# REZONE MAP

BOUNDARY DESCRIPTION:  
N1/2 NE1/4 SE1/4 OF SEC. 7, T12S,  
R65W OF THE 6th P.M., EL PASO COUNTY,  
COLORADO

PETITIONER:  
BLACK FOREST, LLC  
RAD JACKSON, PROJECT MANAGER  
8655 TABLE BUTTE ROAD  
COLORADO SPRINGS, CO 80908-1224

REZONE MAP

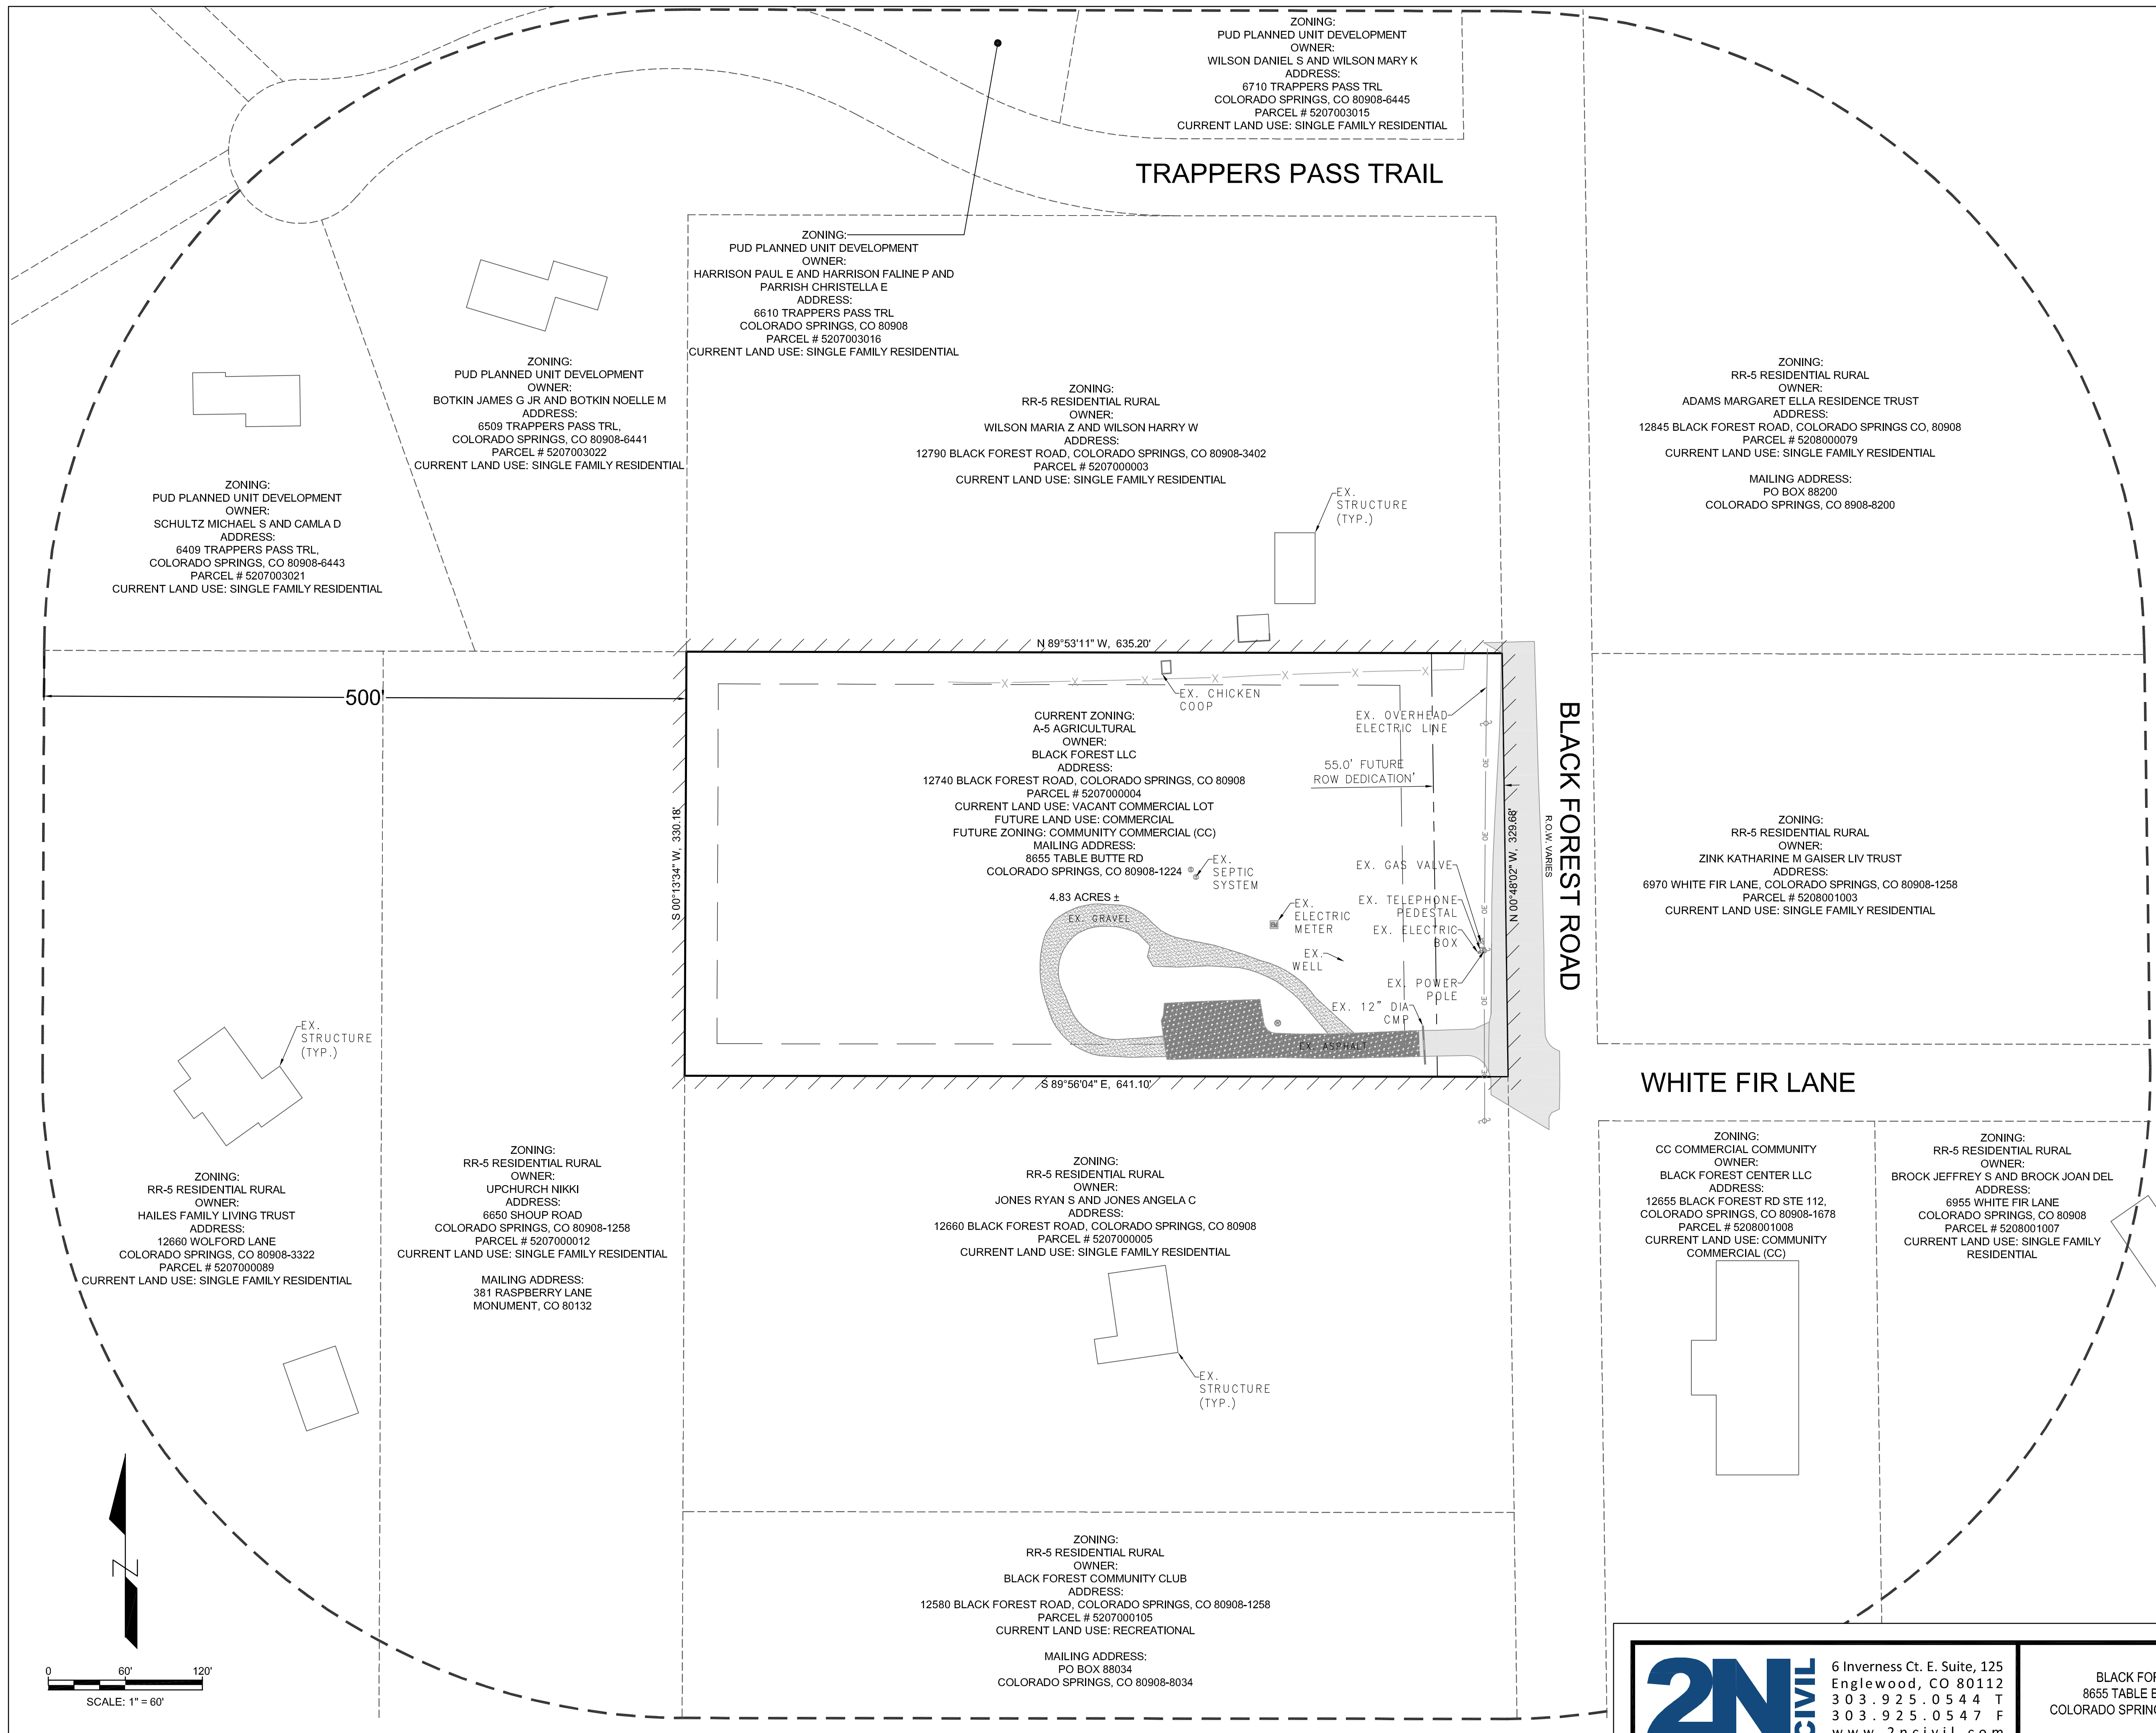
please add in the future land use, future zoning, current land uses description, the surrounding land use descriptions, and the existing structure(s).
